From: Don.Baker@westsussex.gov.uk
Sent: 30 July 2012 14:37
To: Juan Baeza
Subject: Re: AL/37/12/DOC

From: Bruce Taunton
Sent: 06 July 2012 13:00
To: Juan Baeza
Subject: RE: Application reference AL/37/12/DOC

From: Juan Baeza
Sent: 05 July 2012 10:51
To: Bruce Taunton
Subject: Application reference AL/37/12/DOC

Floor Plan

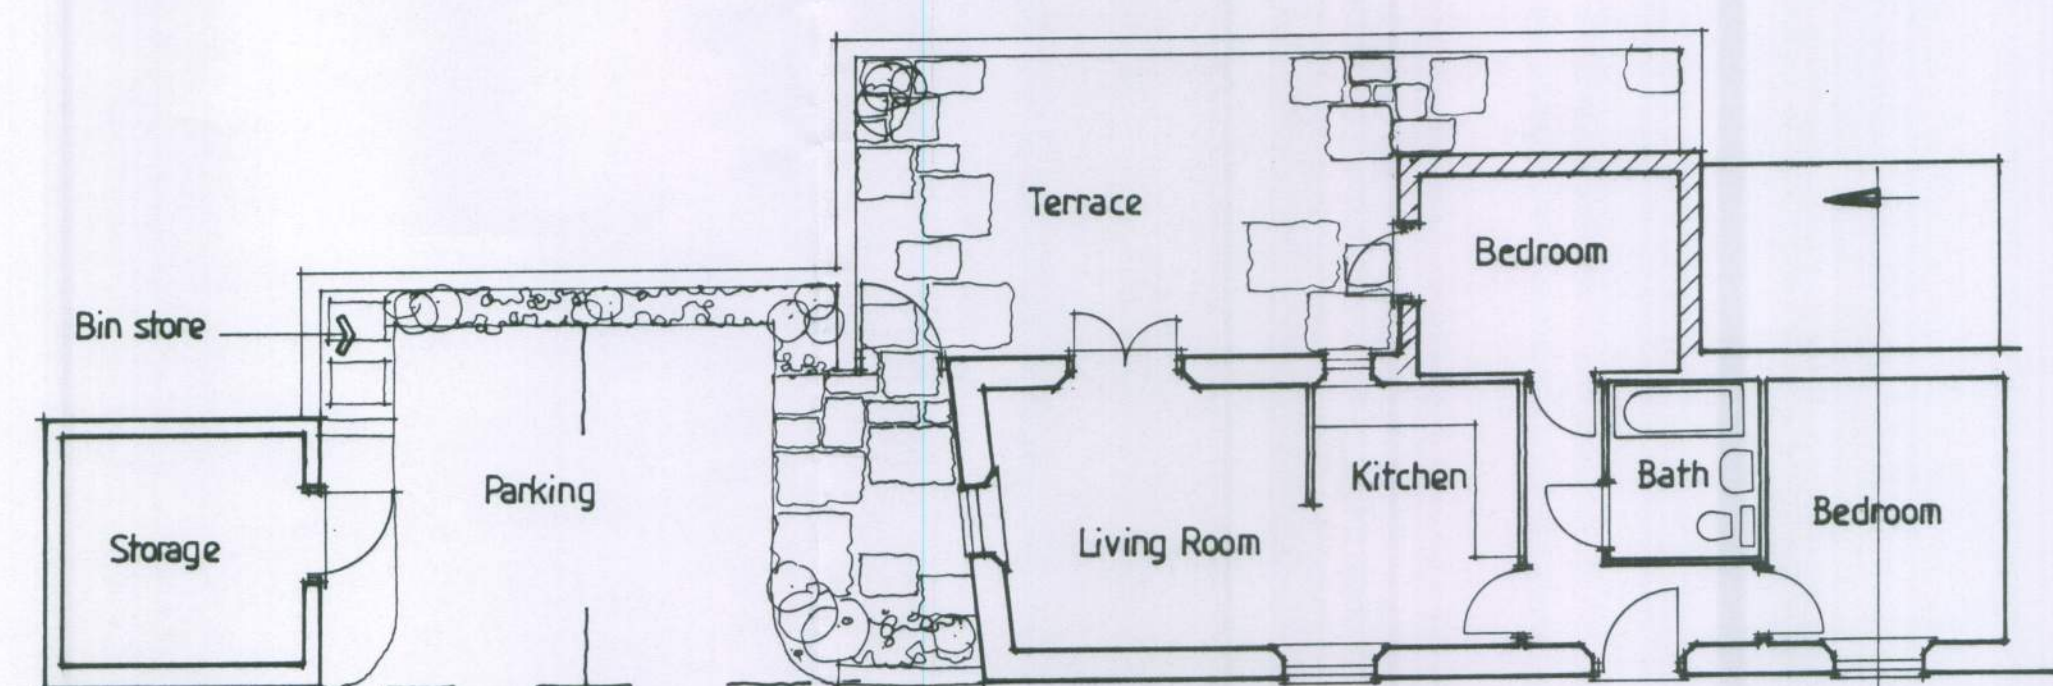
I have reviewed the structural items in the 'Method Statement' and have found that they differ slightly from the structural engineers proposals with respect to the new floor construction. In the recommendations made by Ken Hilton he states that the existing floors could be overlaid with new concrete, however may not have considered the consequences at doorways. The new method statement states that the existing floor will be broken up to allow installation of a new floor. I have no issue with this proposal but would advise that the floor slab requires insulating to meet Building Regulation requirements. This will require additional excavation and care should be taken to ensure that the existing walls remain stable as existing foundations are likely to be shallow.

A further advisory item would be to provide flood protection measures across doorways and foul drains especially in light of recent events in Sack Lane.

PROJECT	Conversion of existing farm building at Sack Lane, Lidsley		
SUBJECT	Proposed Elevations and Sections		
SCALE	1:50	DATE	Feb 2010
DRAWN	CHECKED	DRAWING NO	07 / 87 / 04
		Rev A

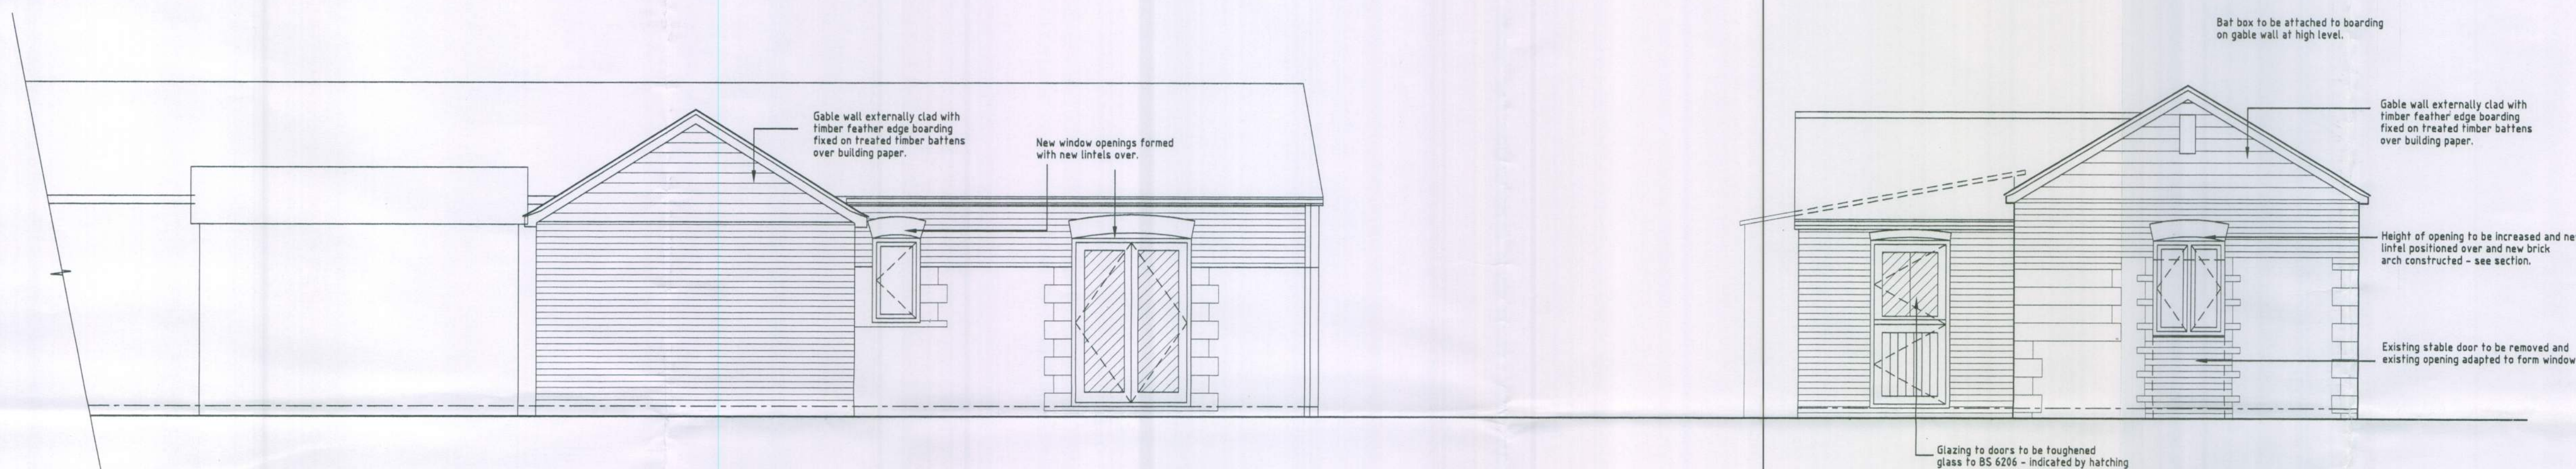
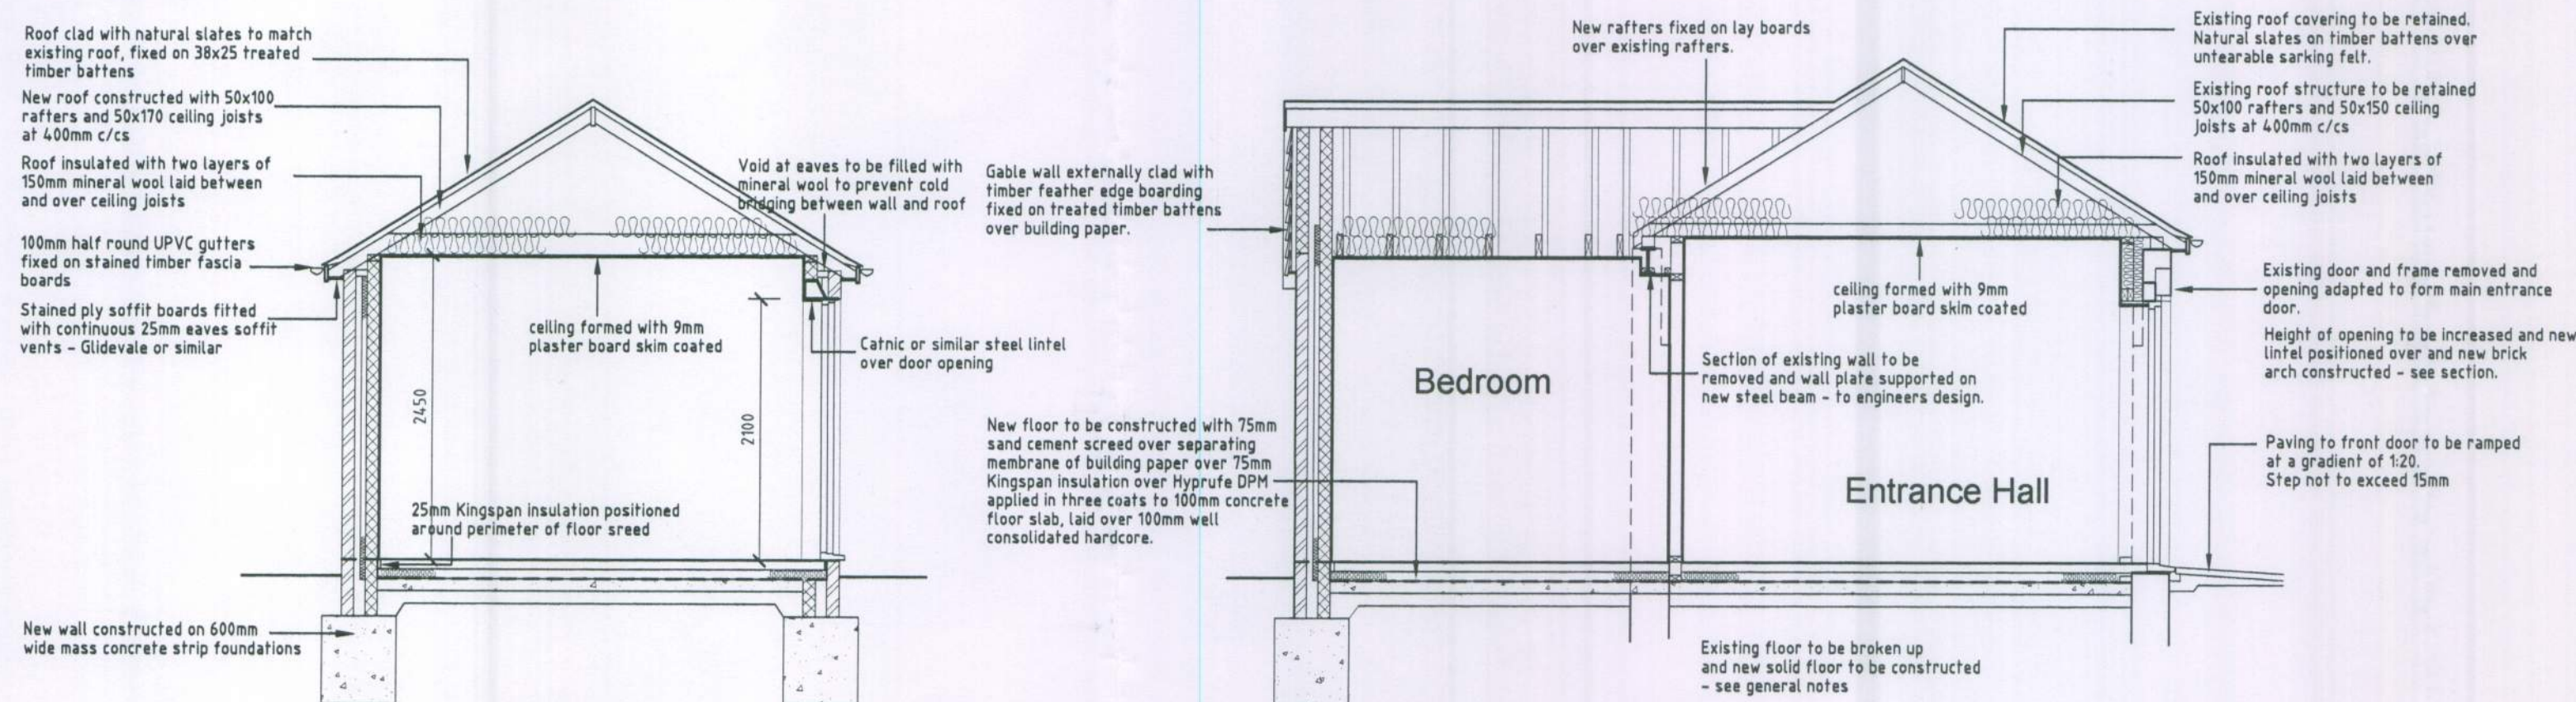
Based on the information supplied, I would have no objection the appropriate discharge of condition 6.
